DECISION DELEGATED TO HEAD OF PLANNING

Application No: H16-0086-24 **Applicant:** Mr J & Mrs E Duda
Proposal: Front & side first floor extensions & alterations
Location: Coneygarth Cowbit Road Spalding
Terminal Date: 29th March 2024

Project address: Coneygarth, Cowbit Road Spalding PE11 2RJ		
Drawing: Plans & Elevations Proposed		
Scale: 1:100@ A1	Drawn By: A.J.	Drawn date: January 2024
Drawing No: 24-018 - P004	Revision:

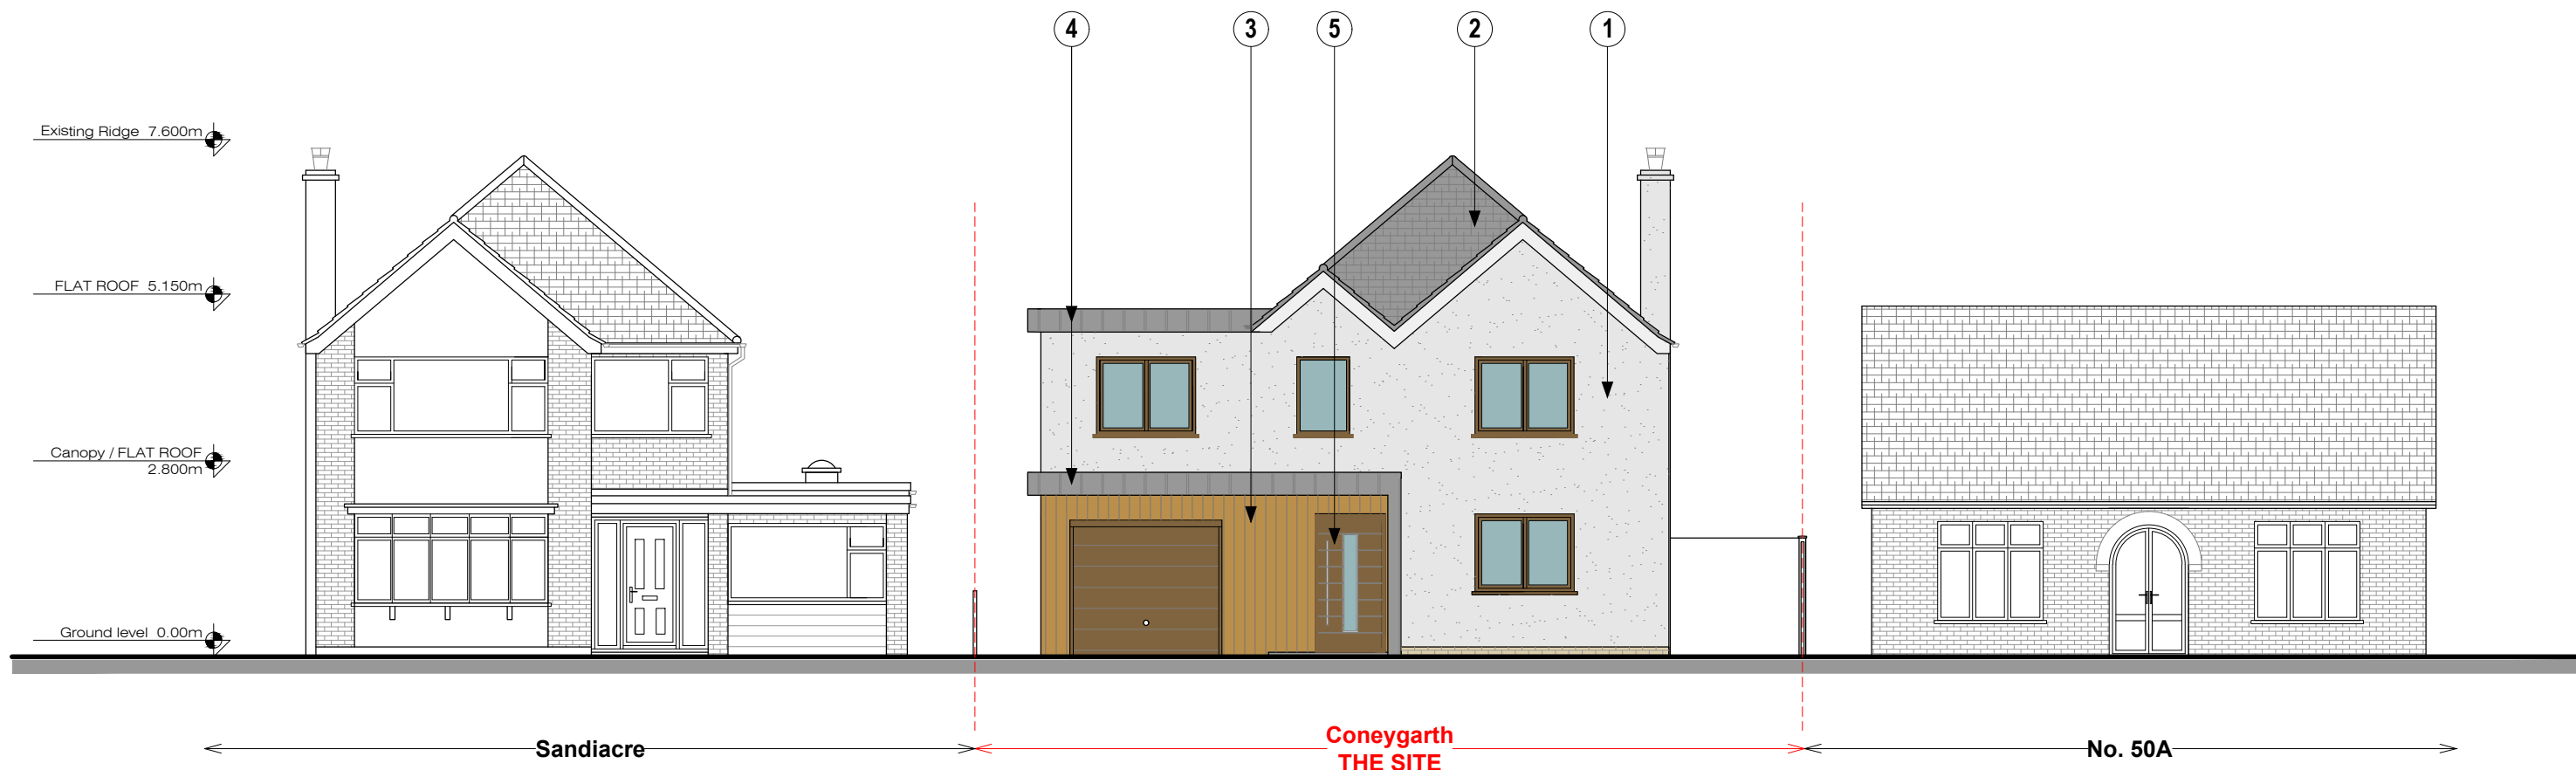
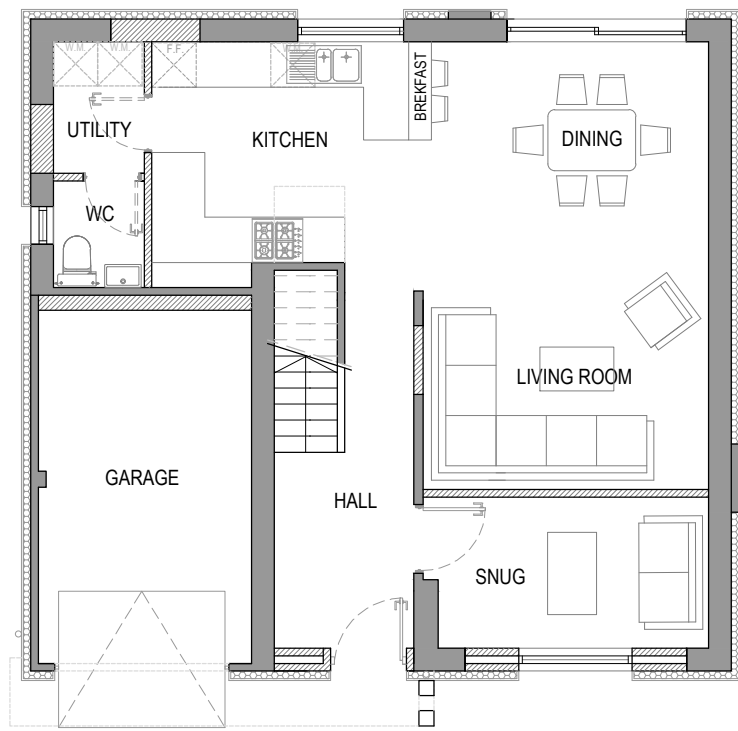
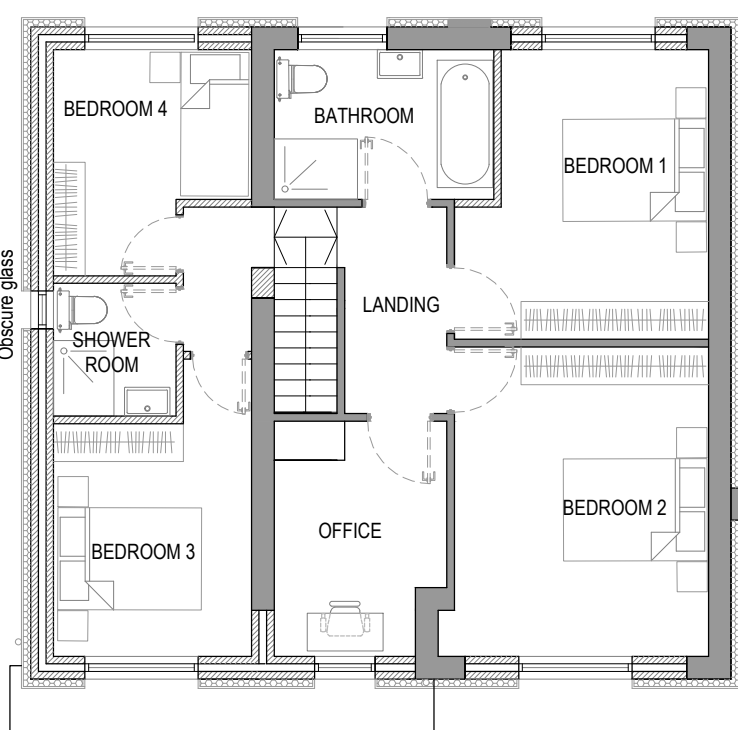
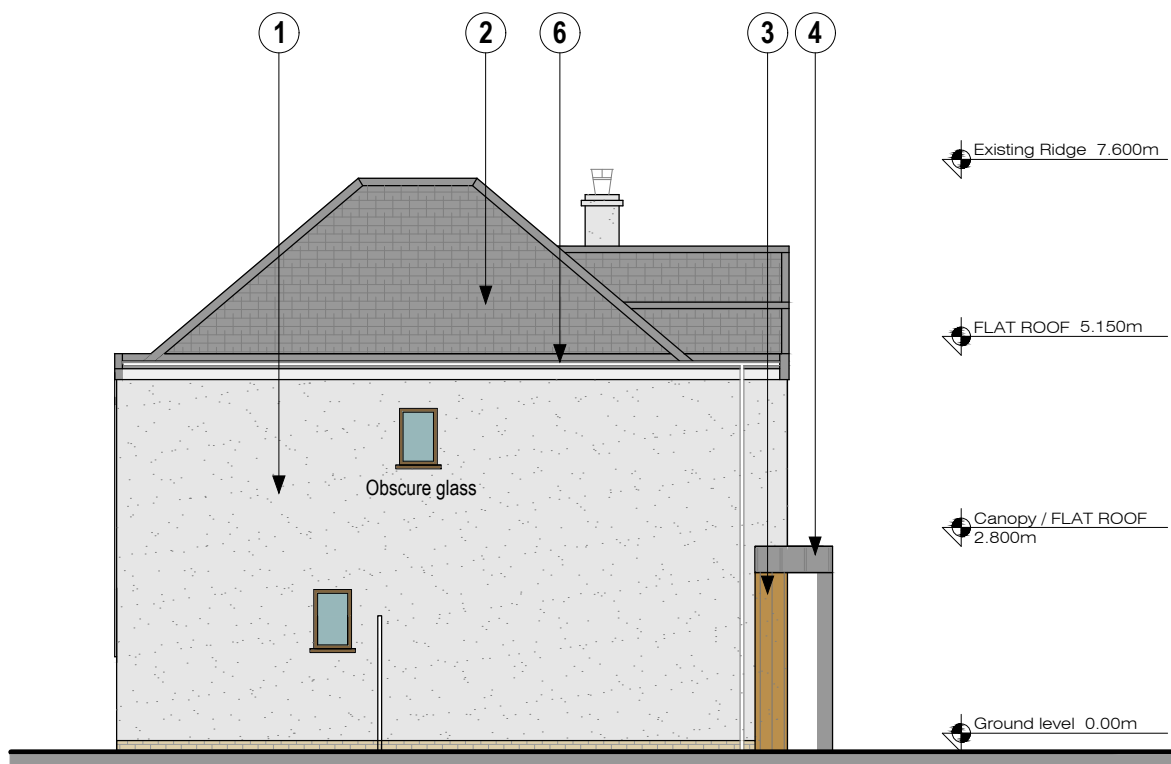
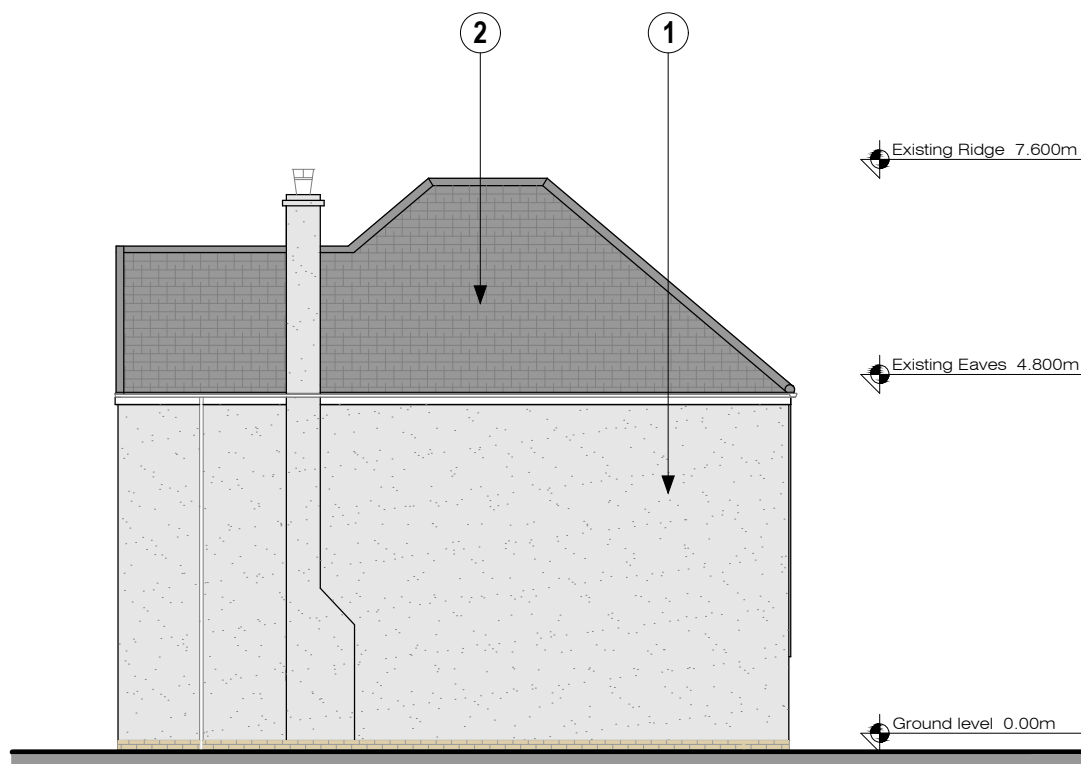
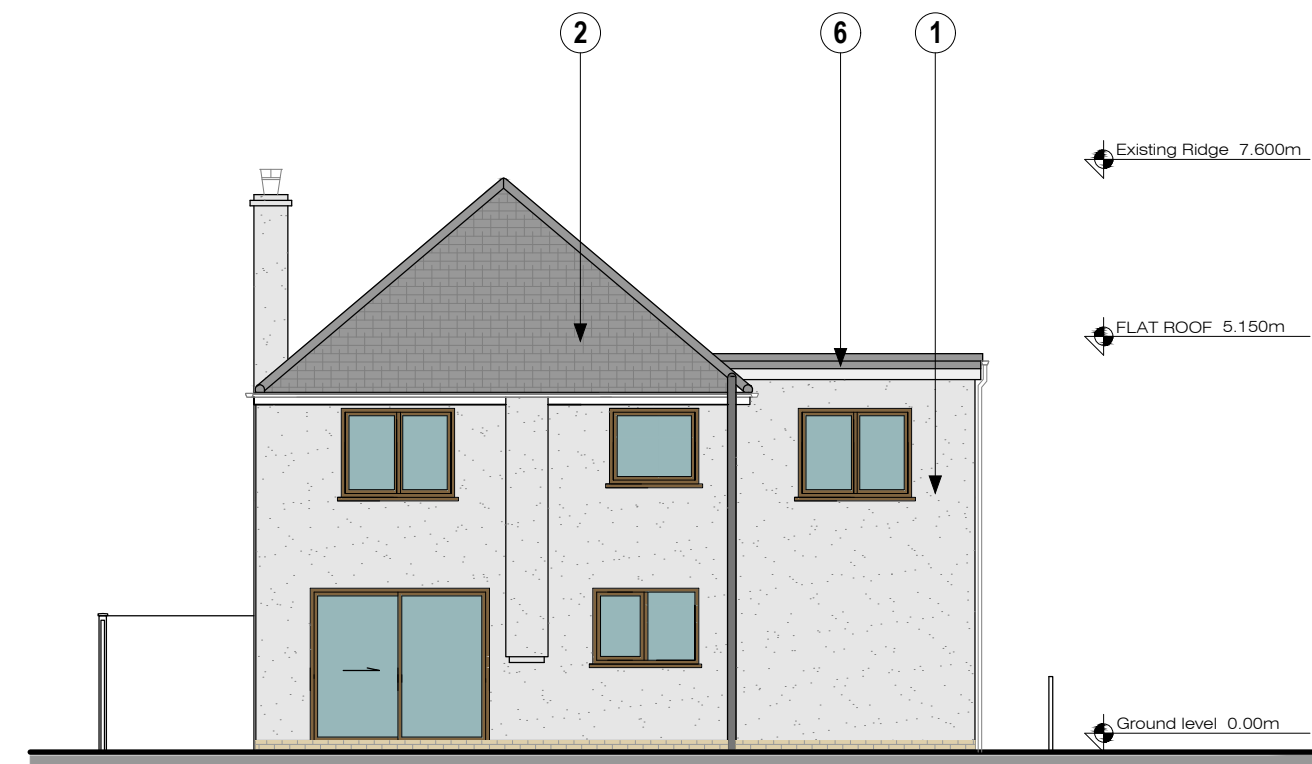
The proposed white render is typical of the area. There are several dwellings within the Cowbit Road area that are rendered white, which would help to naturalise the proposal. That being said, the use of zinc and faux timber cladding is uncommon within the area. There are no comparable materials in the area, with a preference instead being for conventional brickwork and tiling. As such, the proposed materials would appear incongruous in their setting.

While the ground-floor flat roof extensions are not uncommon in the wider area, first-floor roof extensions are an oddity. Without this design feature in order to naturalise the proposal, the flat roof extension, of two storey scale, would appear inappropriate for the area and a significant visual outlier; thereby creating a harmful impact upon the character. This character impact would be exacerbated via the lack of integration with the host that the flat roof extension displays. No attempt has been made to integrate the design with the host, with the use of alternative materials in this portion further exacerbating this point.

Paragraph 3.3.3 of the SELLP (within the justification for Policy 2) states that "any extension is carefully designed to respect and relate to the original building and integrates sensitively with the character and appearance of the surrounding area". The introduction of a visually discordant extension, which is poorly integrated into the host, would directly conflict with this aspect of the adopted development plan.

It is considered that in the immediate area, there are no precedents for this variety of side extension or roof design. As such, whilst precedent would not result in a proposal being acceptable or unacceptable, given that each application must be considered on their own merits, the lack of similar designs within the surrounding area does further indicate that the proposal is uncharacteristic and it is considered that the proposal would appear incongruous and harmful to the street scene. As the proposal is located on the first floor of the dwelling, the impacts of this unacceptable design would be exacerbated, causing unacceptable harm to the character of the area. As such, it is considered that the proposal is contrary to the ideals of good design outlined within the National Design Guide and would fail to accord with the requirements of good design detailed within Policy 3 of the SELLP.

Taking account of the design, scale, and nature of the development, as detailed above, the proposal is considered to be unacceptable. The proposal would cause an adverse impact to the character or appearance of the area and would therefore be in contrary to Policies 2 and 3 of the SELLP and

The development hereby proposed would materially harm the character and appearance of the locality. The proposal would introduce an incongruous feature, severely at odds with the character of the area. The design would not be fully integrated into the host dwelling or the wider area. These concerns are exacerbated by the first-floor location, making the extension appear unduly prominent and harmful to the street scene.
